From: Nicola Oktay on behalf of Planning.Responses
Sent: 09 April 2025 12:29
To: Planning Scanning
Subject: FW: RE: Planning consultation on: BR/50/25/PL

Planning Consultee response – Arun Houses in Multiple Occupation Officer

Please see Private Sector Housing comments below. These comments are in relation to general housing conditions and have regard to the Housing Act 2004, Housing Health and Safety Rating System (England) Regulations 2005 and LACoRS national fire safety guidance.

Main building - Ground Floor

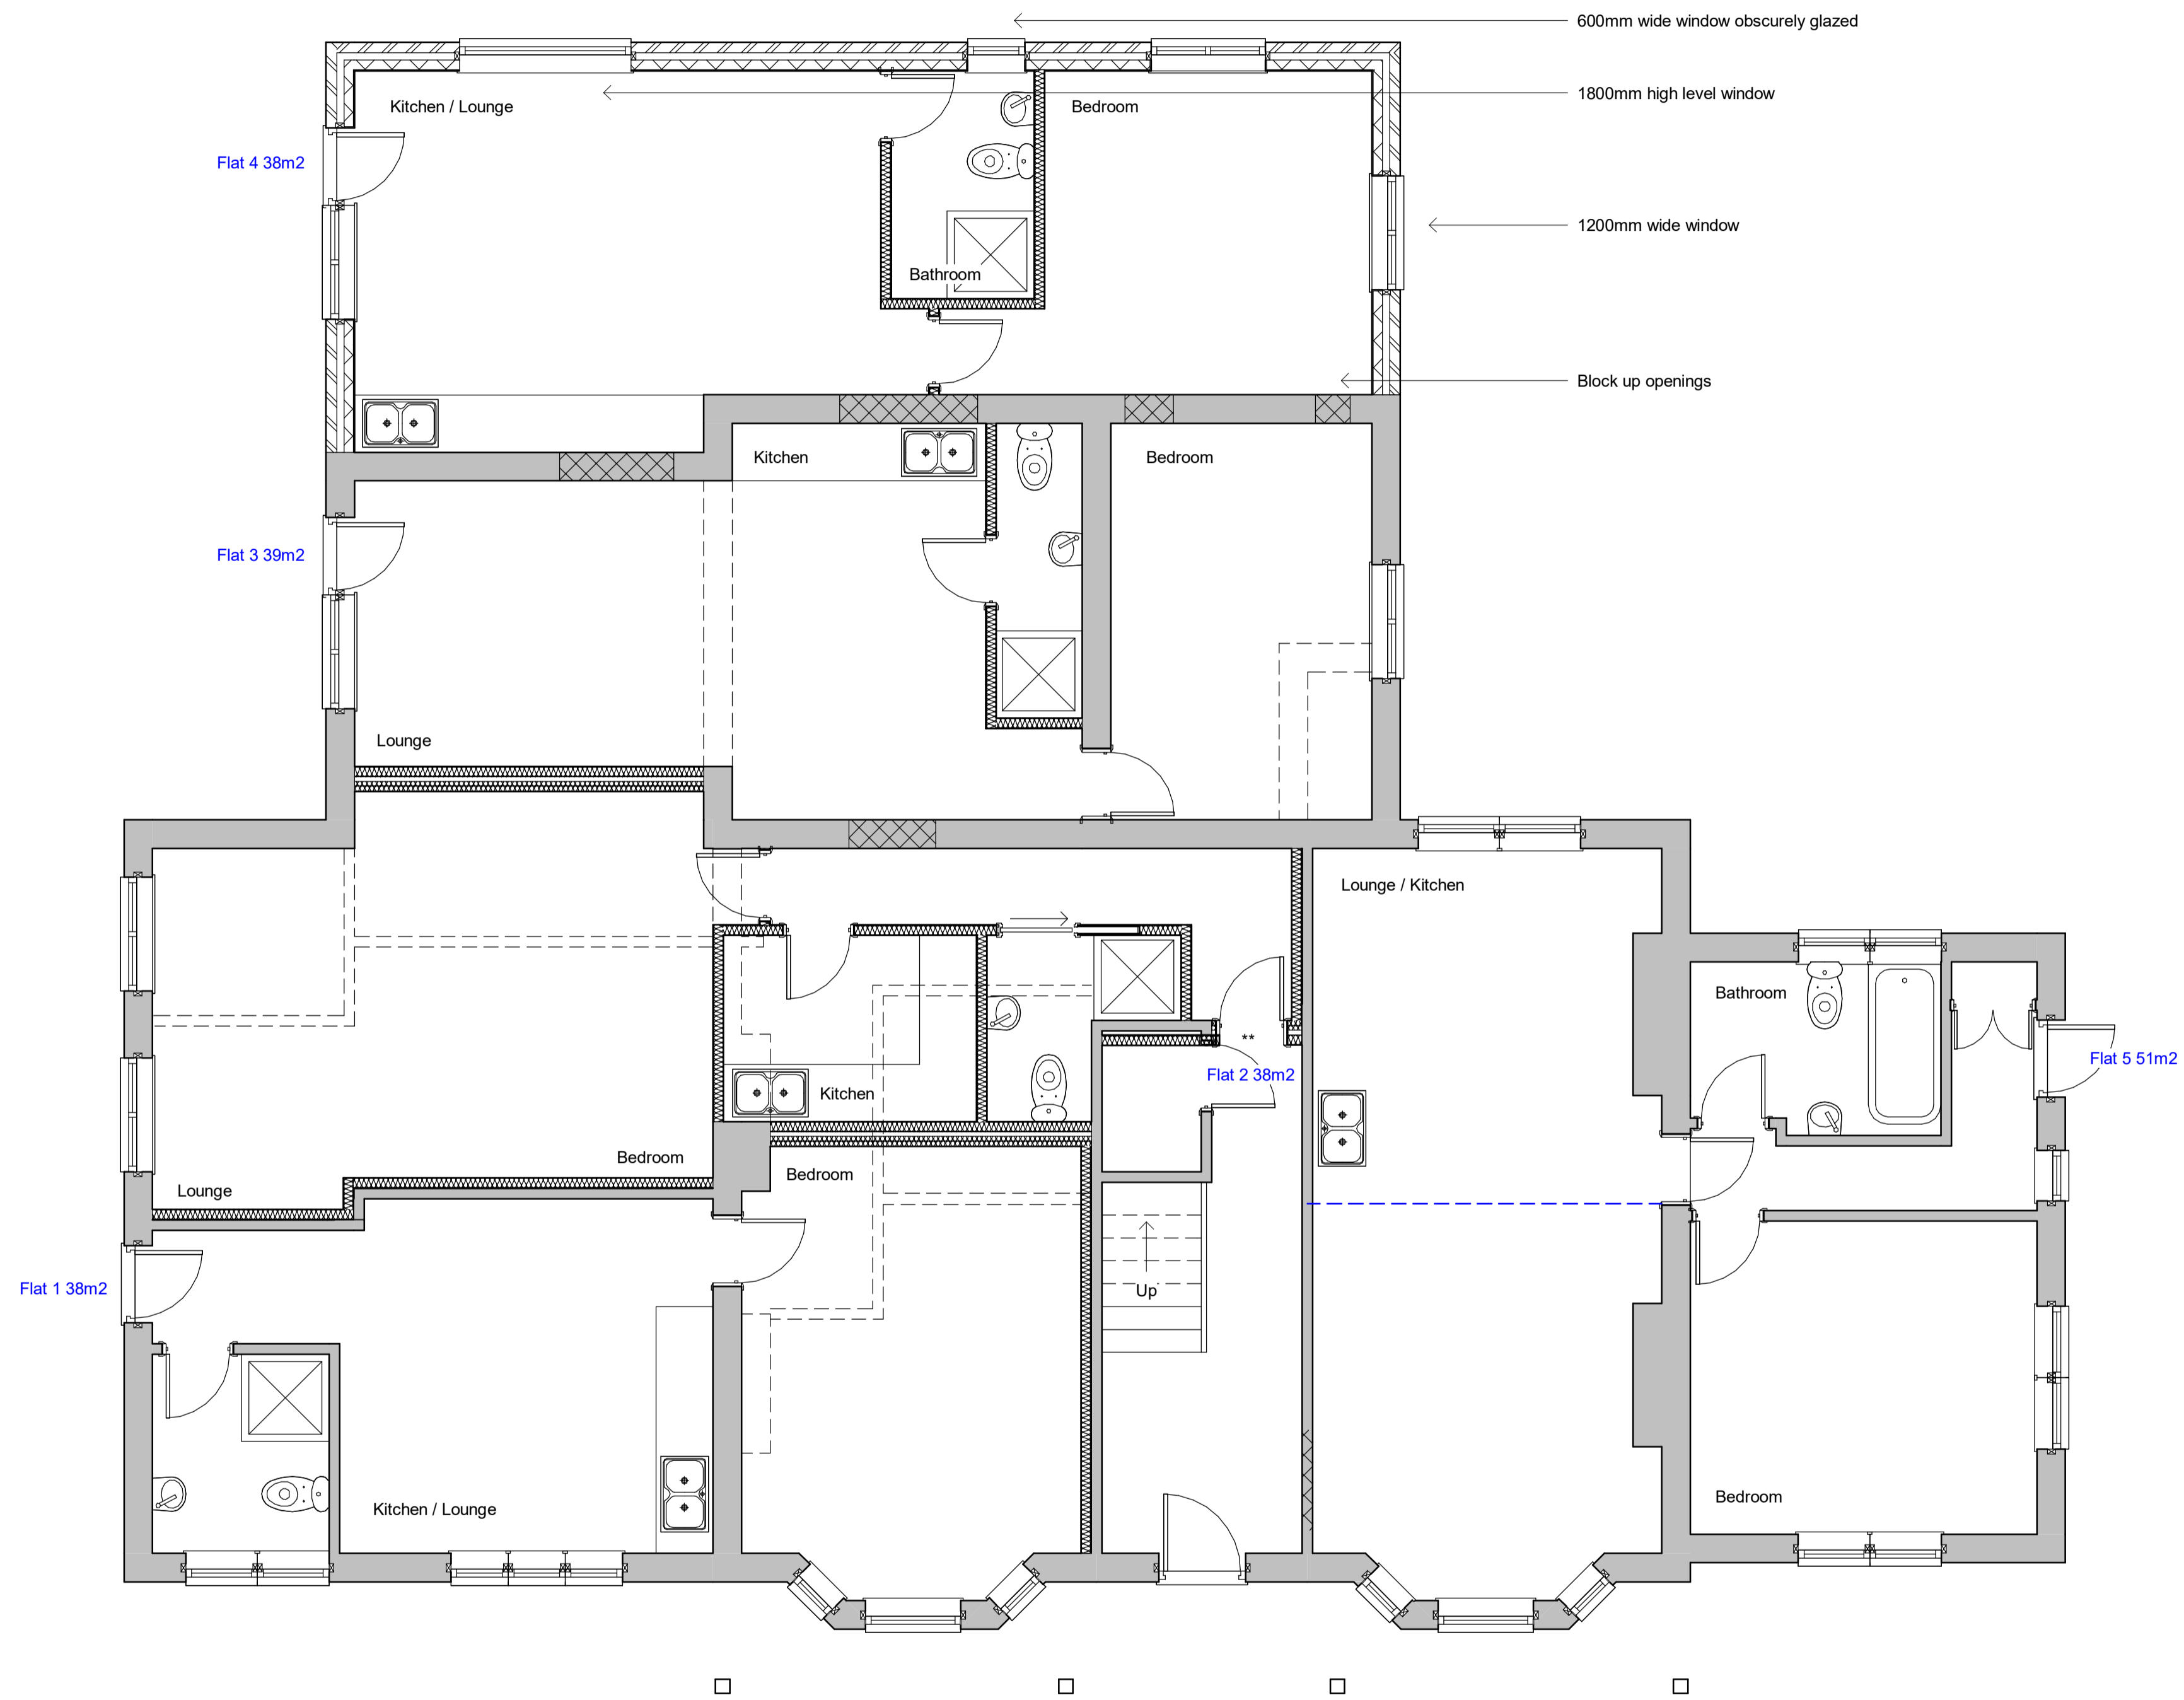
- The bedrooms within Flats 1, 3, 4 & 10 are inner rooms. A room where the only escape route is through another room is termed an “inner room” and poses a risk to its occupiers if a fire starts unnoticed in the outer room. In both cases, the outer rooms are the lounge/kitchen which are high risk rooms. This can be overcome by providing the following additional fire safety measures:
- Escape windows installed to the bedrooms to provide an alternative means of escape;
- FD30S doors fitted to the bedrooms; and
- Smoke detection installed to the kitchen/living room (liaise with a fire alarm engineer for best placement to avoid false alarms from cooking) with an interlinked smoke detector installed to the inner hallway

- The internal communal escape route should provide a minimum of 30 minutes fire resistance, including any service cupboards and understairs areas, and 30-minute fire resisting and self-closing fire doors (FD30S) must be fitted to each flat entrance door. Doors to any service cupboards and understairs areas must also be 30 minute fire-resisting and kept shut with a lock and with appropriate signage.
- All final exit doors from the building, and from each individual unit into the internal escape route should be fitted with an internal thumb turn latch

- A mixed Grade A, LD2 and Grade D LD3 fire alarm system should be installed and maintained. Grade A detection comprises electrically operated smoke and heat detectors which are linked to a control panel. The control panel must conform to current BS 5839: Part 4 or equivalent and incorporate manual call points next to final exits and on each landing. Grade A: LD2 coverage is required in the common areas and a heat detector in each flat in the room/lobby opening onto the escape route (interlinked). Grade D: LD3 coverage in each flat (non-interlinked smoke alarm in the room/lobby opening onto the escape route) to protect the sleeping occupants
